2024/0054

17 Redhaw Road, Royston, Barnsley, S71 4GE

Erection of detached double garage with hipped roof (Amended Plans & Description).

Drawing Title
PROPOSED PLANS

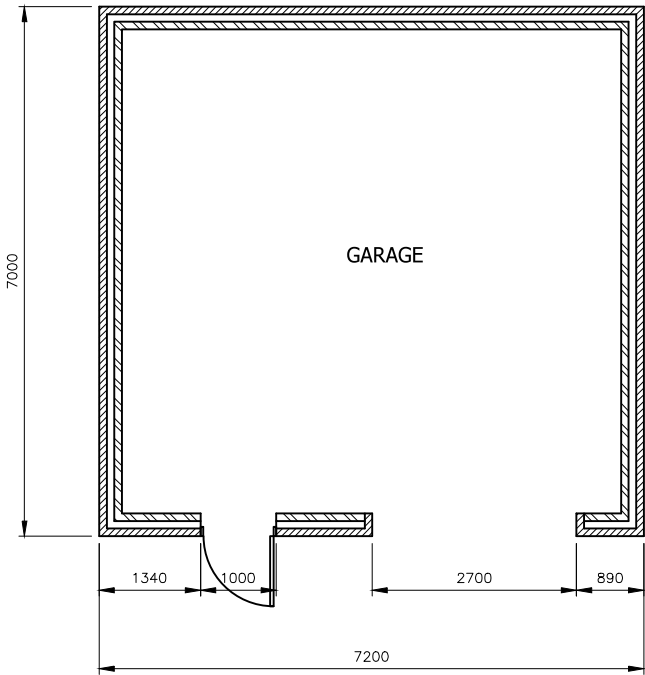
The proposed garage would adopt the scale of a double garage and would be located to the south of the application site and erected immediately adjacent the east, south and west boundaries. It is acknowledged that the proposal could result in some overshadowing. However, any potential impact is likely to occur and be limited to the morning or evening and not at peak times for use of a rear garden. Moreover, any potential impact is likely to be limited to the southernmost parts of the rear gardens of adjoining and adjacent properties. Additionally, existing boundary treatments comprising high timber fencing is likely to offer some mitigation and could further lessen the impact on surrounding properties. Properties immediately to the south of the application site (Midland Road) benefit from very limited rear garden space and the proximity of the extension to the southern boundary could contribute to some overshadowing. However, as the extension would be located to the north of these properties, any potential impact is not considered to be significantly detrimental, especially as existing boundary vegetation could contribute to any existing level of impact which may be experienced and tolerated.

The proposal would provide an additional 2no. off-street parking spaces and would not interfere with existing parking arrangements to the front. Moreover, Highways DC were consulted on the application and raised no objection to the proposal.

Drawing Title
PROPOSED ELEVATIONS

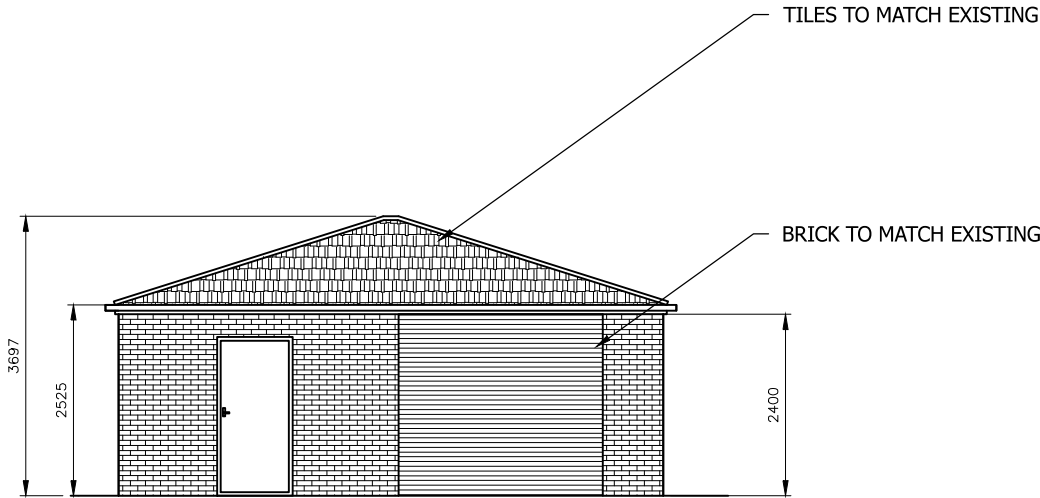
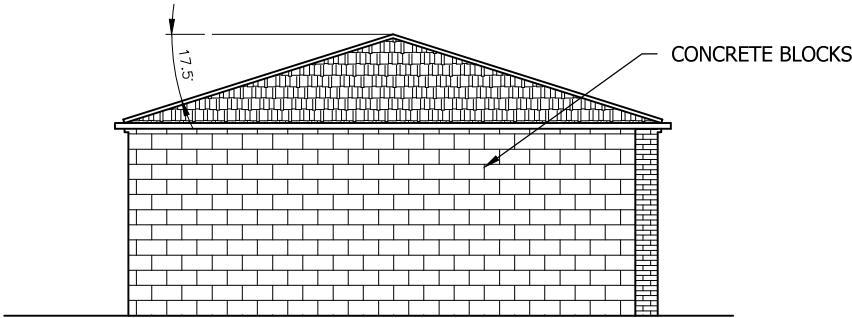
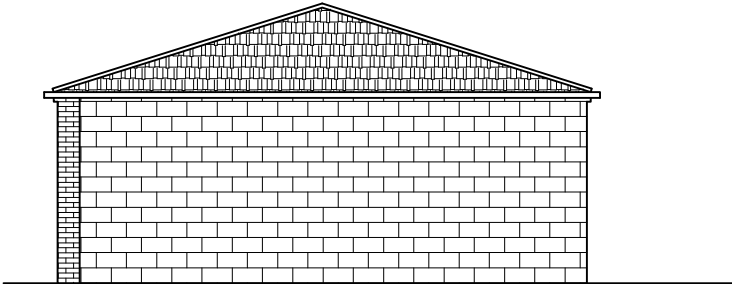
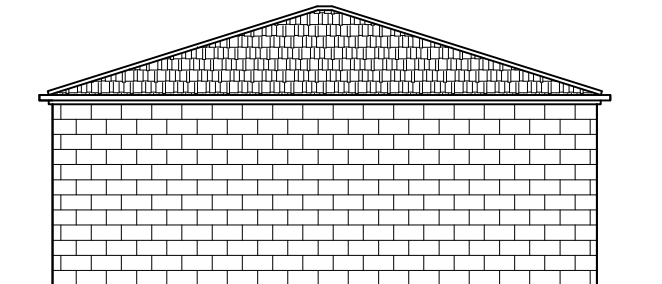
The original proposal sought permission for a detached garage with a pitched roof. However, concerns were raised regarding potential overshadowing impacts. Subsequently, the proposal was amended.

The proposed garage would adopt a hipped roof with an eaves height of approximately 2.5 metres, in accordance with the SPD. Moreover, a hipped roof would lessen the overall height of the building and could act to further lessen any potential impact to surrounding properties. Additionally, a garage of this scale could be erected as permitted development (therefore not requiring planning permission) if a flat roof with a total height of 2.5 metres was adopted.

The proposed garage would adopt the scale of a double garage and would adopt a sympathetic form and features, including a hipped roof and brickwork to its north-facing (front) elevation. The side and rear elevations of the garage would remain as exposed concrete blockwork. Brickwork to all elevations would have been preferred. However, the garage would be located to the rear of the application dwelling and would not be a prominent feature within the street scene. As such, it is not considered that the proposal would significantly detract from the character of the application dwelling nor the broader street scene.

The applicant is now seeking permission for the erection of a single storey detached garage with a hipped roof. The proposed garage would measure approximately 7 metres by 7.2 metres externally and 6.4 metres by 6.6 metres internally. The garage would adopt a hipped roof with an approximate eaves and ridge height of 2.5 metres and 3.7 metres respectively. The garage would be constructed of blockwork with facing brickwork to its front (north) elevation.
